FW: LU/141/25/PL 57 River Road Littlehampton

Further to our reply on the 8th of September with drawing A_600 Swept Path Analysis, we just wanted to check if there are any updates from the Highways team or further details you would like from us.

North Arrow	
Project	
47 River Rd, Littlehampton BN17 5BF	
Drawing Title	Drawing Number
PROPOSED SWEPT PATH ANALYSIS - CAR PARK	A_600
Scale	Date
1:250 @ A3	26/04/2024
Status	Revision
PLANNING	P_01

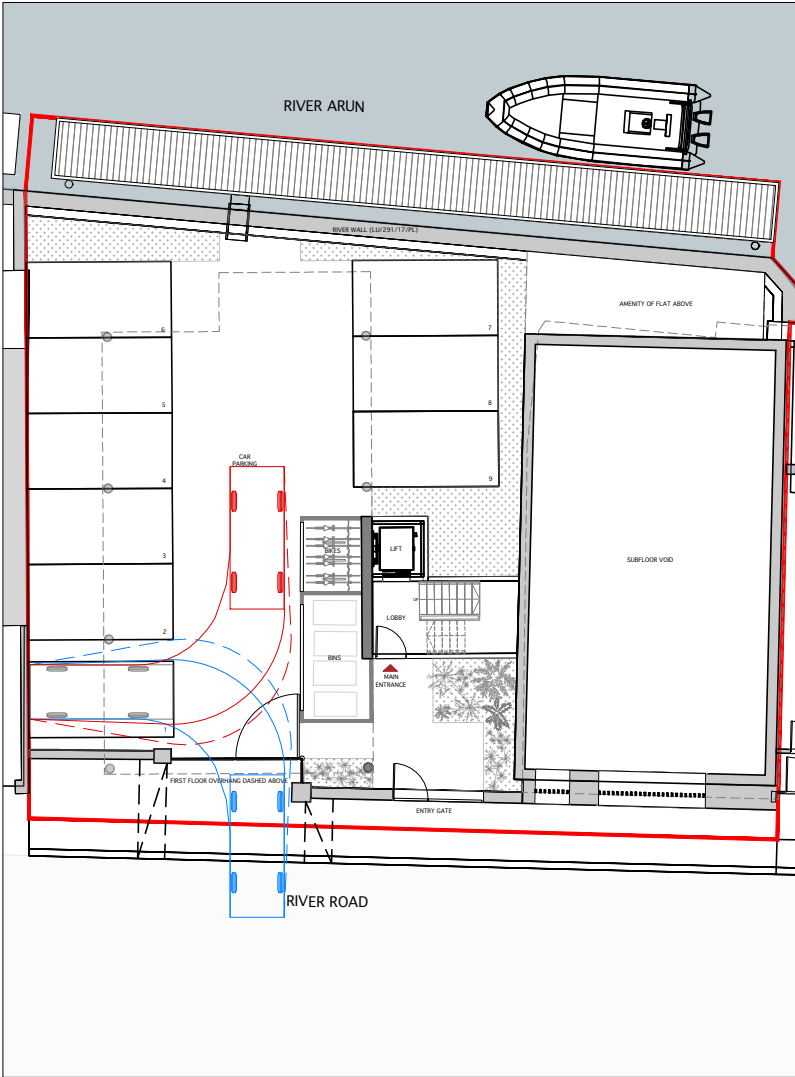
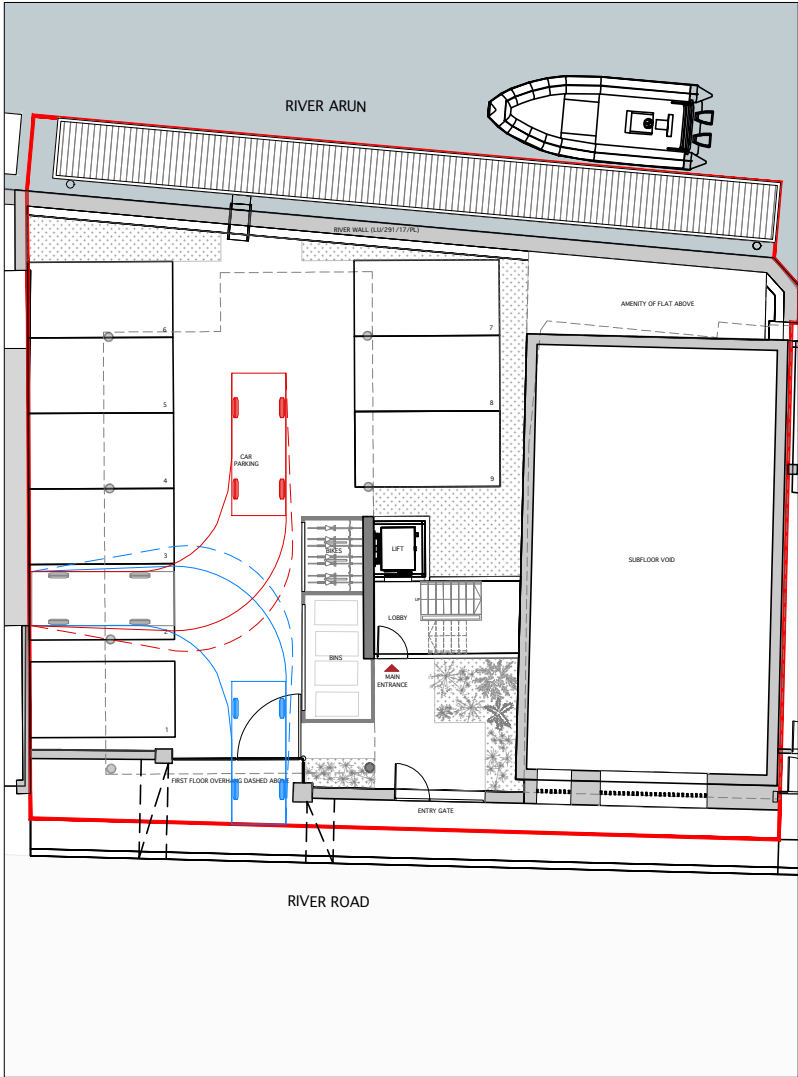
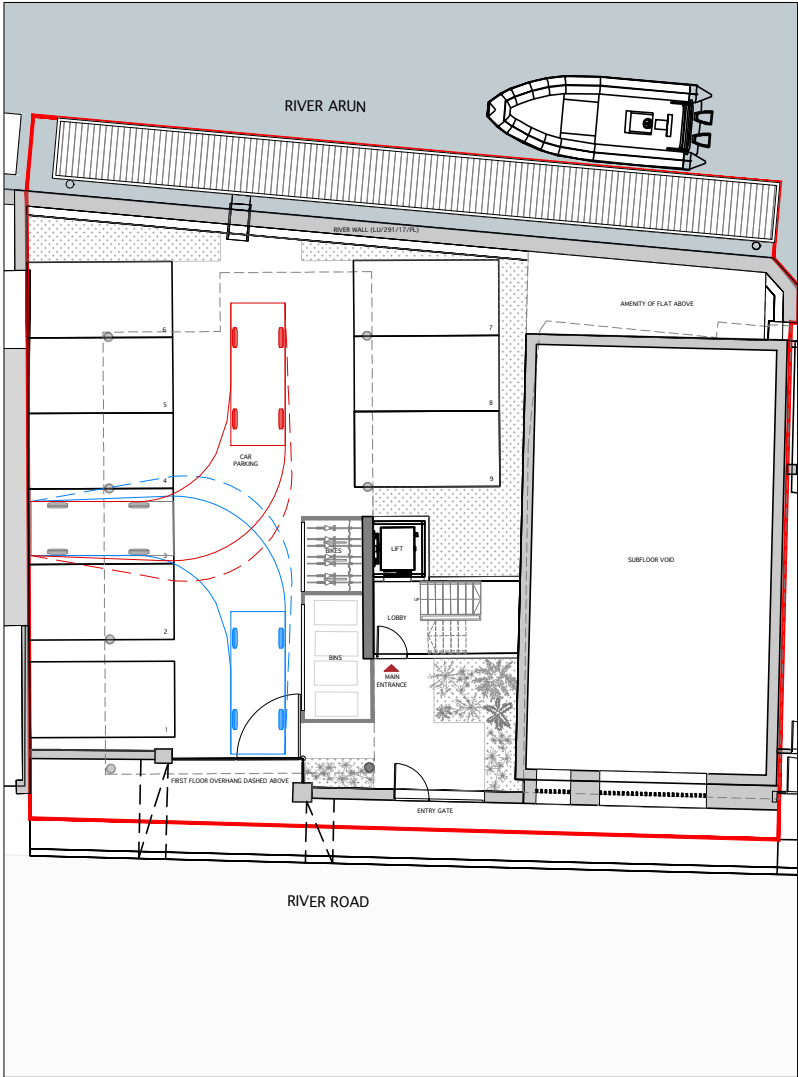
Further to the below, please see the attached Highways comments. They may not have seen the plan showing the tracking for parking space 1 but regardless they also ask for details ref parking spaces 2 and 3. Can you provide an amended plan to me, and I will then re-consult them.

I write to ask whether you can arrange for some tracking drawings to demonstrate how cars will enter and exit parking space 1 (by the entrance) in a forward gear.

In response to their request, please see attached drawing A_600 Swept Path Analysis. This plan demonstrates tracking movements for a standard vehicle entering and exiting Parking Spaces 1, 2 and 3 in forward gear. The swept-path analysis confirms that access and turning can be achieved within the site for these bays.

RESPONSE: Please see the attached revised drawing A_100, which includes tracking for Parking Space 1 as requested. The swept-path analysis illustrates a standard vehicle (refer to the notes column for details) entering and exiting Parking Space 1 in forward motion. We trust that these diagrams will satisfy the requirement.
